1 Introduction

2 Item 3a - Impact on Health

3 Item 3a - Battery Energy Storage System (BESS) Safety

Plate 3-5: Illustrative Battery Enclosure (Source: Recurrent Energy)

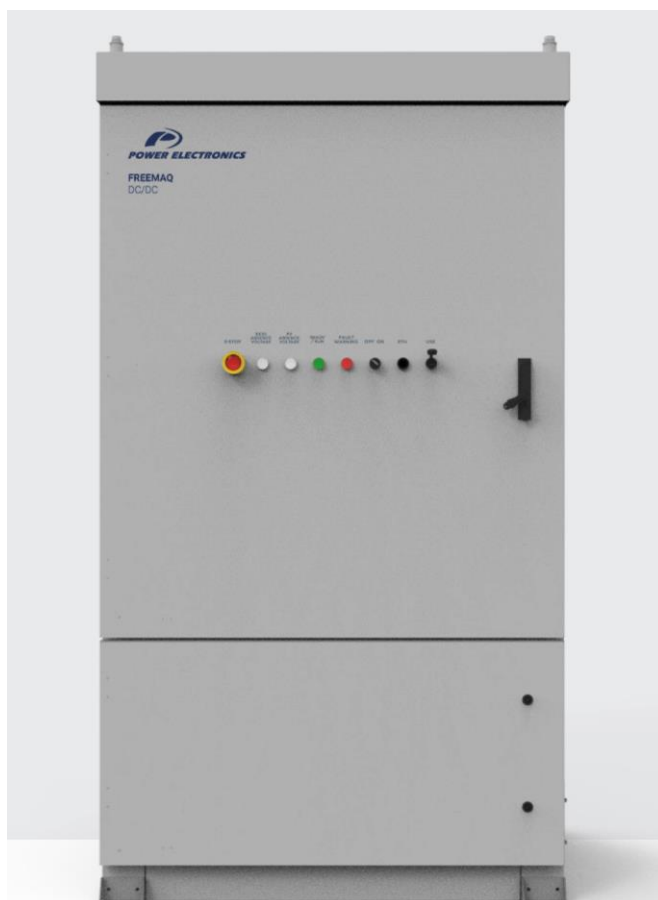
The Applicant’s Framework Battery Safety Management Plan (APP-225) is very high level. It does not currently assess dormant failures, such as thermal protection or fire suppression systems failing to operate.

The Battery Management Safety Plan does not provide any real detail on the sub-systems they intend to use. Furthermore, many of the mitigations for Thermal Runaway they cite, such as thermal management, fire detection and suppression, have a very high industry failure rate that would not be permitted in any other high-risk environment.

I am concerned that the Applicant has not provided a clear and comprehensive explanation of the intended design for their BESS. I accept that a Rochdale Envelope may be applied to the scheme, but PA 2008 Advice Notice Nine Paragraph 2.3 states:

I believe the current description of the scheme is inadequate.
